Our Ref: WA/53/20/NMA

**Section 96A of the Town & Country Planning Act 1990 (as amended)
Town and Country Planning (Development Management Procedure) (England) Order 2015 (as amended) - Article 10**

Non material amendment following grant of WA/36/20/HH for the increased width of proposed kitchen and reduced width of proposed study.

Murroes Dairy Lane Walberton BN18 0PT

project: 20/C05
drawing no: 2c
date: March 2020

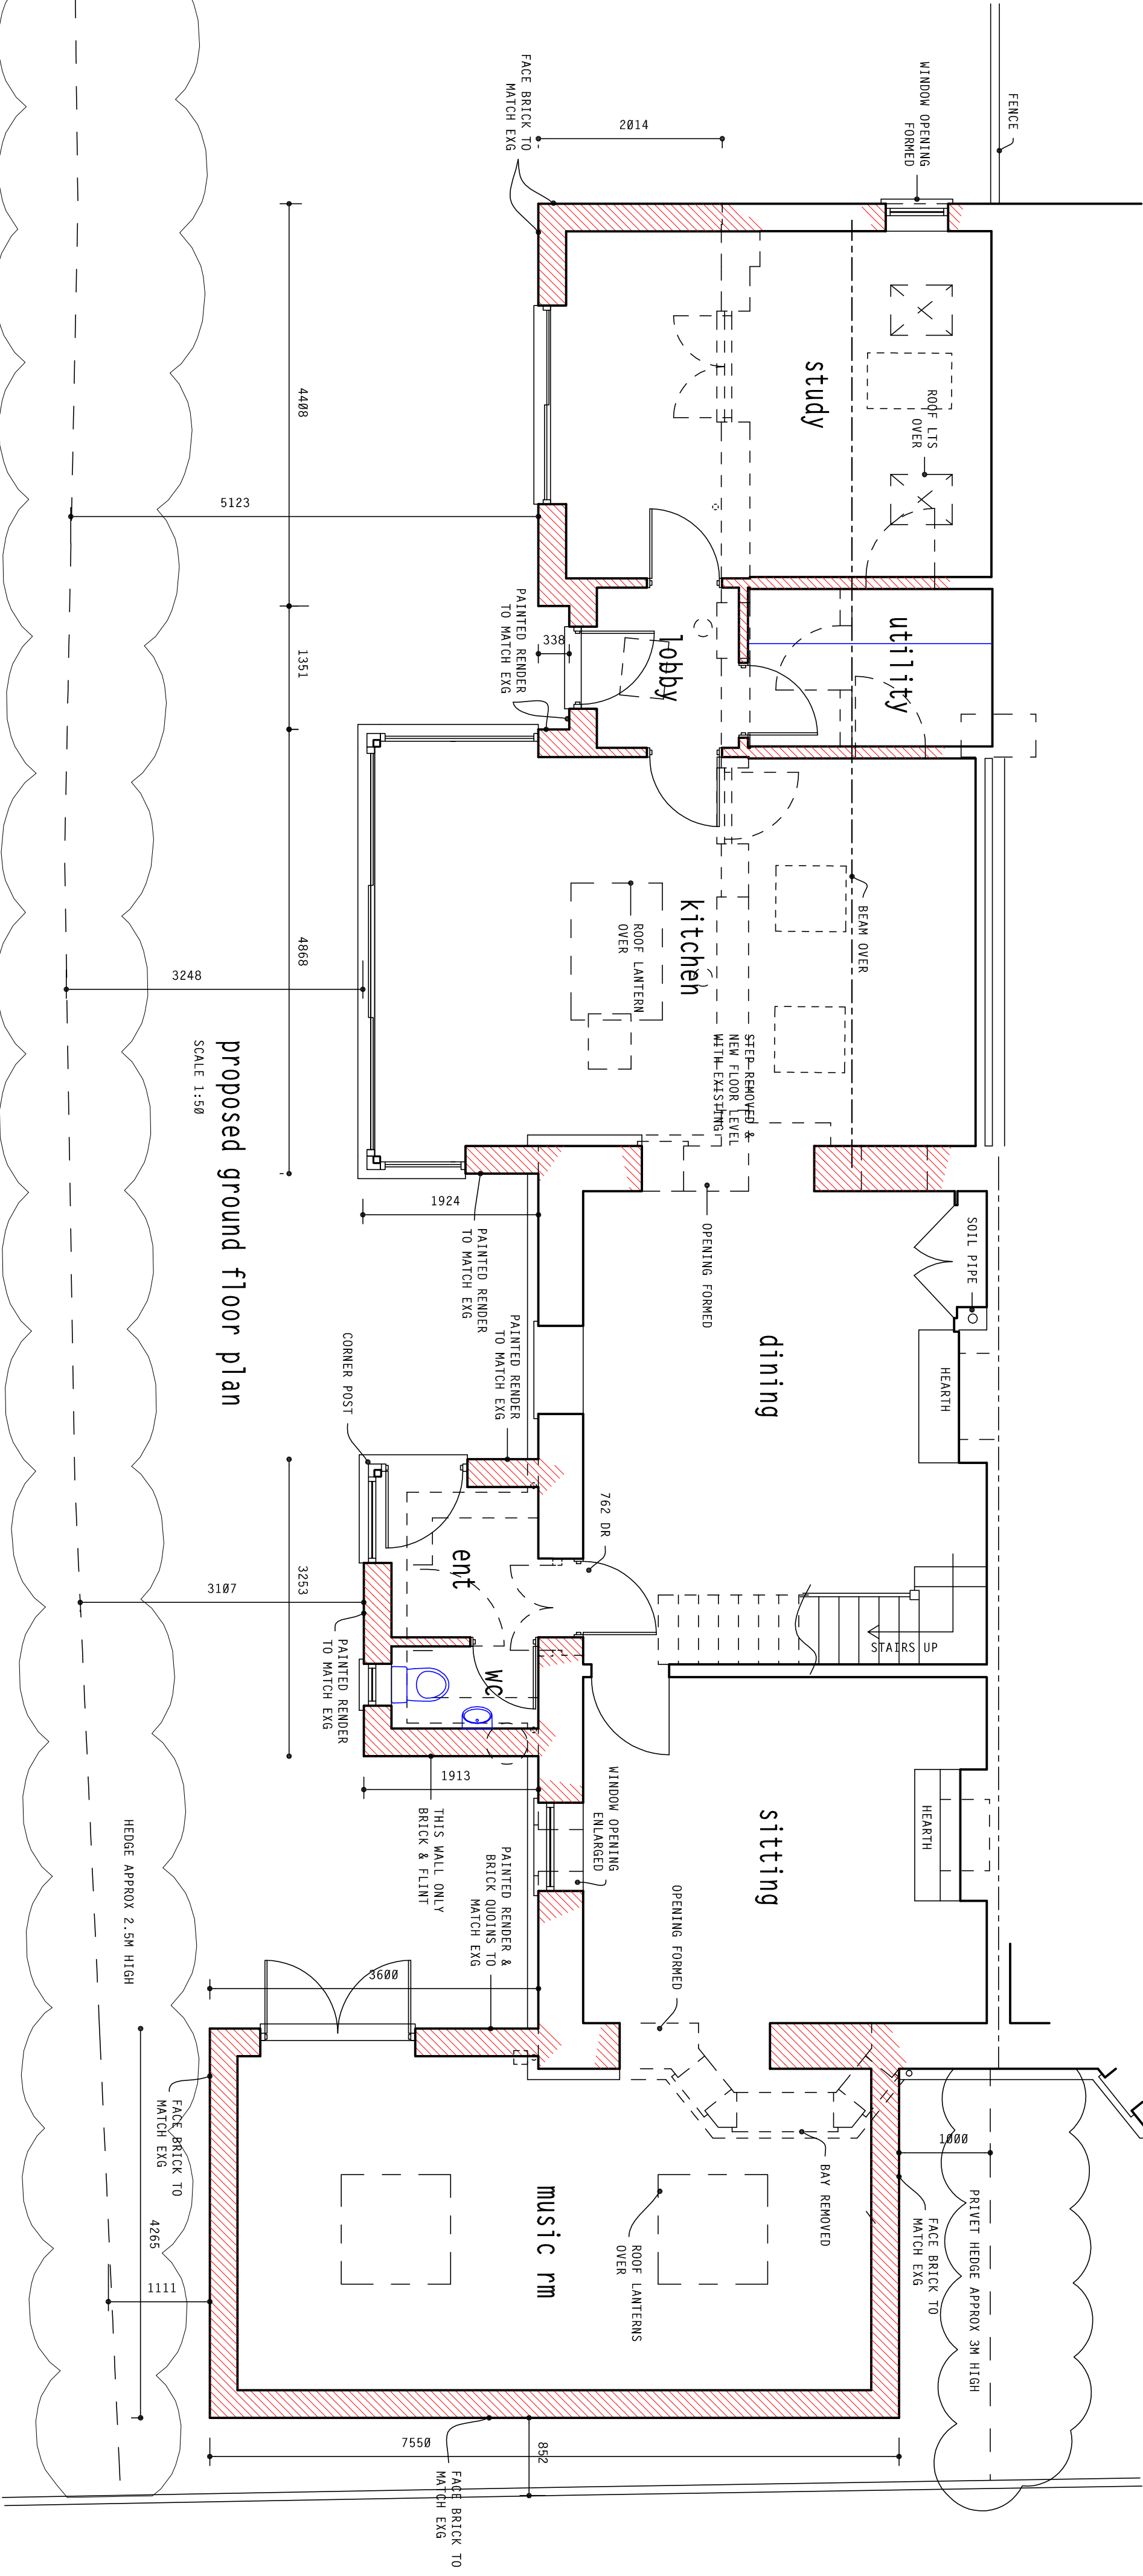
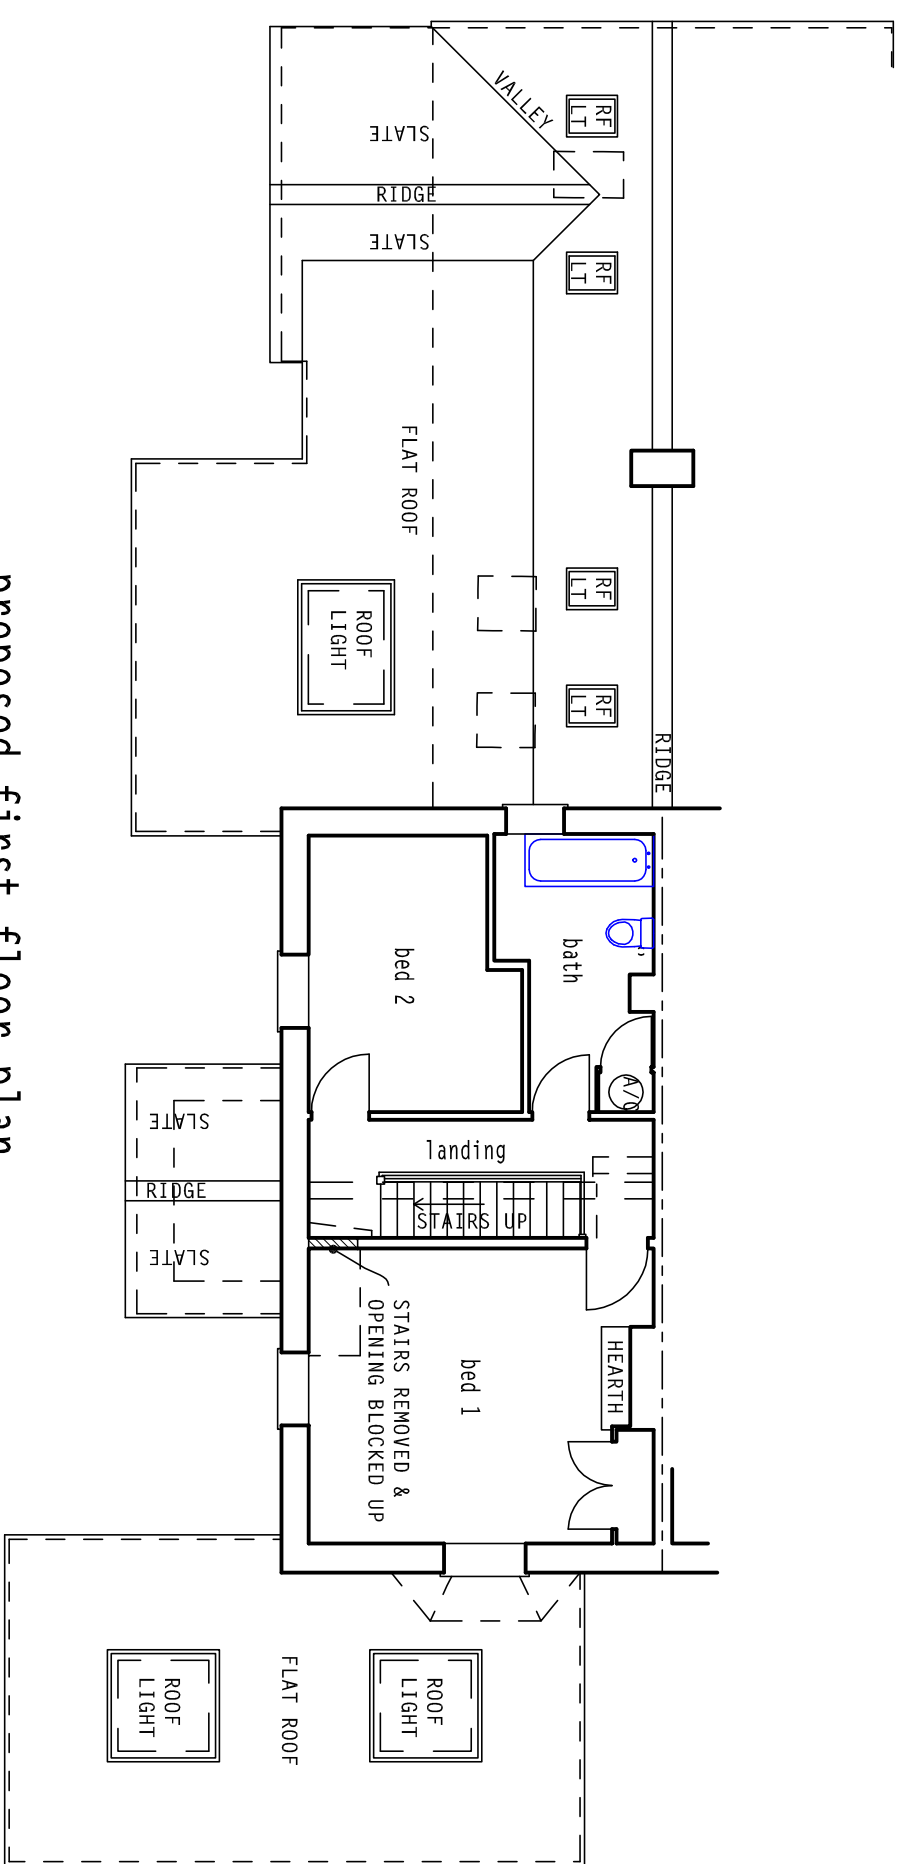
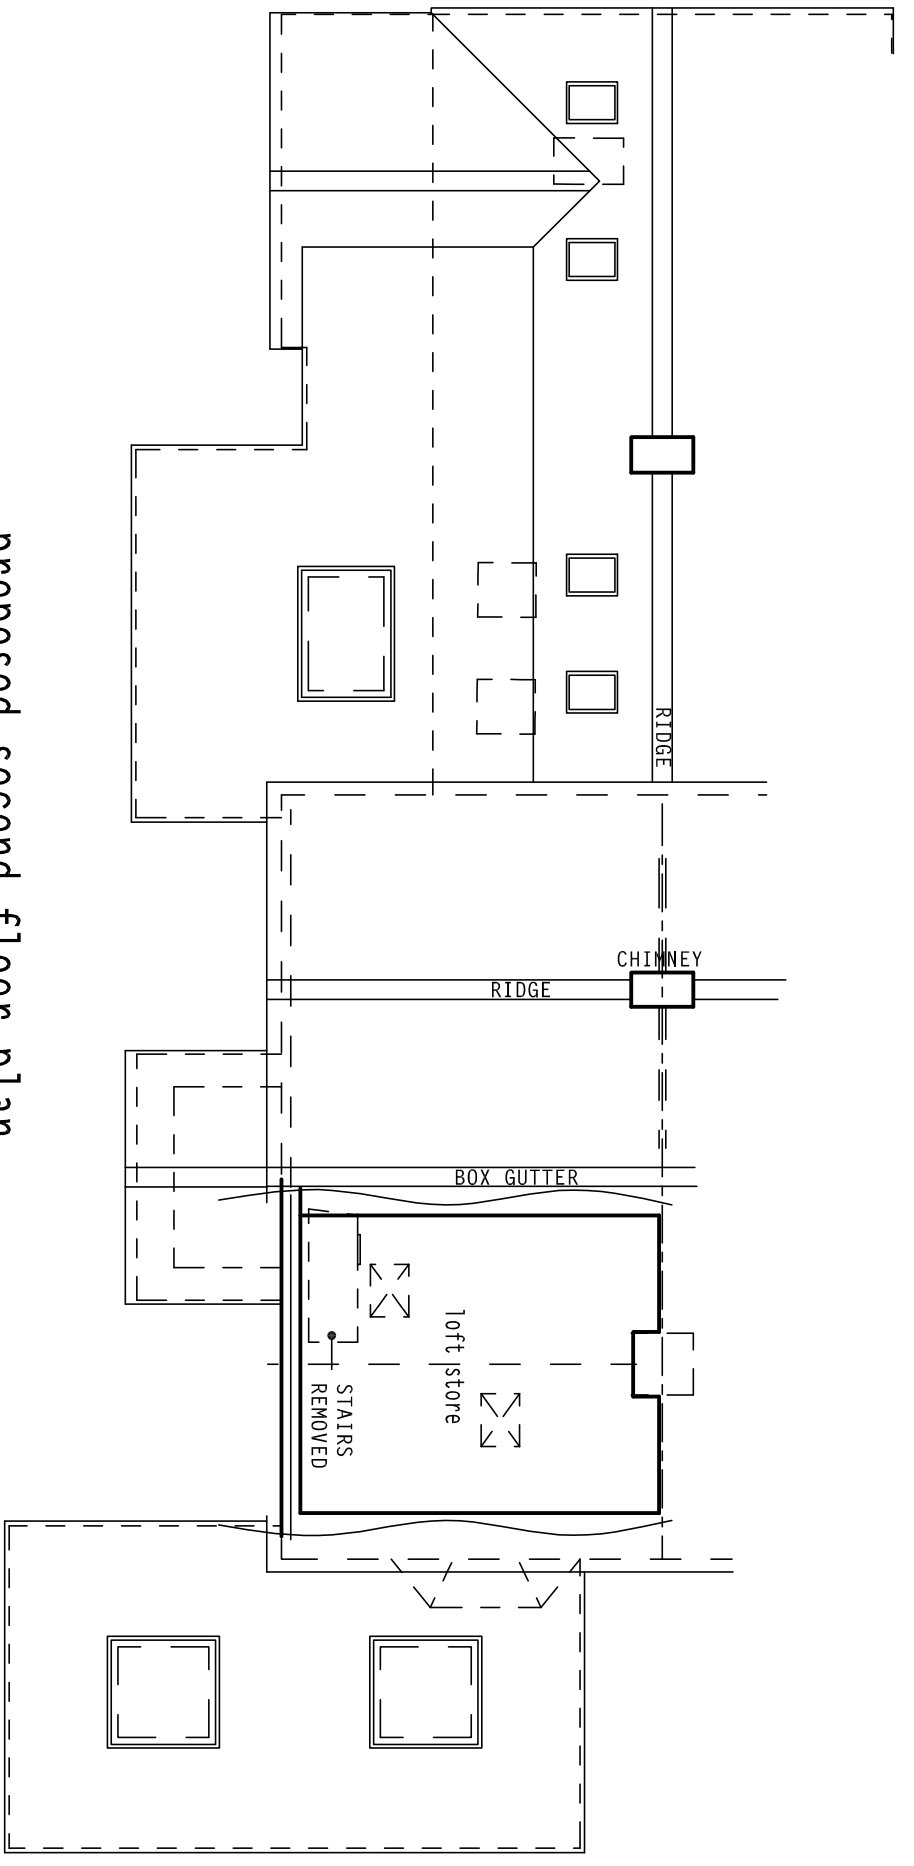
I refer to your recent application for a Non Material Minor Amendment. I understand that you wish to increase the width of the kitchen by 0.7m, and reduce the study width by 0.7m.

The approved plans 'Plans - 20/C05 - 3b - March 2020' and 'Plans - 20/C05 - 2c - March 2020' are hereby replaced by 'Plans - 20/C05 - 3c - March 2020' and 'Plans - 20/C05 - 2d - March 2020'.
